RE: REVISED Transmittal of Comments – Elita Short Plat (SP-08-00041)

TO: Community Development Services
FROM: Christina Wollman, Planner II *CW*
DATE: October 22, 2009
SUBJECT: Elita Short Plat SP-08-00041

RE: Upper County Plat Application – Elita Short Plat (SP-08-41)

ELITA SHORT PLAT
KITITAS COUNTY SHORT PLAT NO. 08-XX
PORTION OF THE SE 1/4 OF SEC. 9, TWN. 19N., RGE. 15E., W.M.
KITITAS COUNTY, WASHINGTON

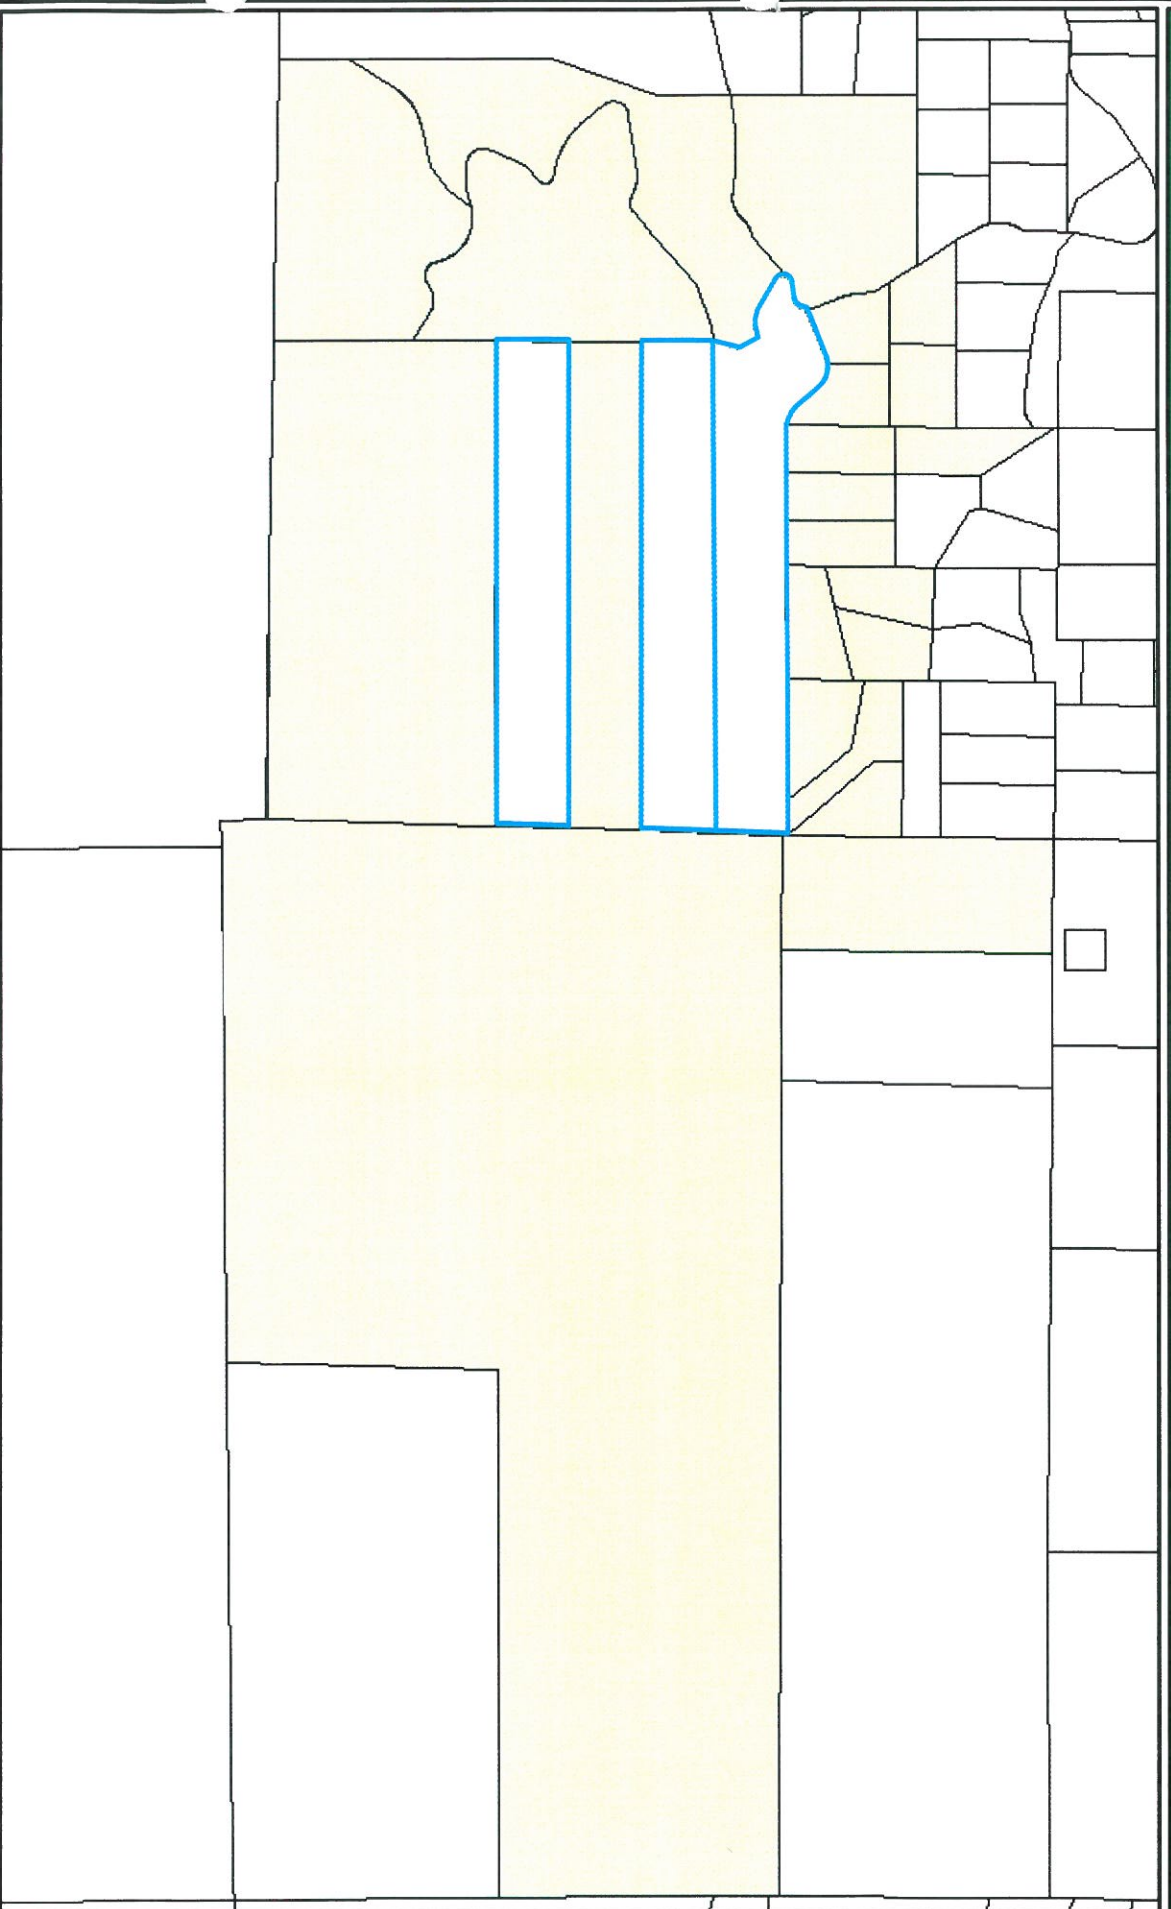
Second Access: A second access is required of this project. Prior to final approval, the applicant must submit a route that has easement or other access rights secured and recorded to Public Works for approval. The second access must conform to Kittitas County Road Standards and the second access requirements as clarified by the Board of County Commissioners on April 2, 2007. The BOCC clarified KCRS 12.01.095(2) with the following requirements: 1) If the second access is restricted to emergency access only, it must meet or exceed the following requirements: 60' easement, 20' roadway width, BST/ACP surface, and a paved apron. Access restrictions such as gates or bollards must be approved by the Fire Marshall; 2) If the second access is to be used for ingress and egress, it must meet the same standards of the first access.

Creek Crossing: Prior to crossing the creek, the applicant shall ensure all necessary provisions are taken and permits applied for. Crossing location shall be determined to be suitable prior to final approval.

3. Second Access: The second access route shall be shown on the final plat or within the vicinity map.
4. Improvements to South Cle Elum Ridge Road and Rocky Mountain Road: From Westside Road to the entrance to the Plat, access roads shall be constructed as High Density Roads that serve 40+ lots.

5. Cul-de-Sac: A cul-de-sac turn-around having an outside right-of-way or easement diameter of at least 110 feet shall be constructed at the end of Rocky Mountain Road. The driving surface shall be at least 96 feet in diameter. Cul-de-sacs must also conform to the requirements specified by the 2006 International Fire Code. Contact the Fire Marshal regarding any additional cul-de-sac requirements.

6. Joint-Use Driveway: A joint-use access shall serve no more than two tax parcels. See Kittitas County Road Standards, 9/6/05 edition.
 - a. Access easements shall be a minimum of 20' wide. The roadway width shall have a minimum width of 12'.
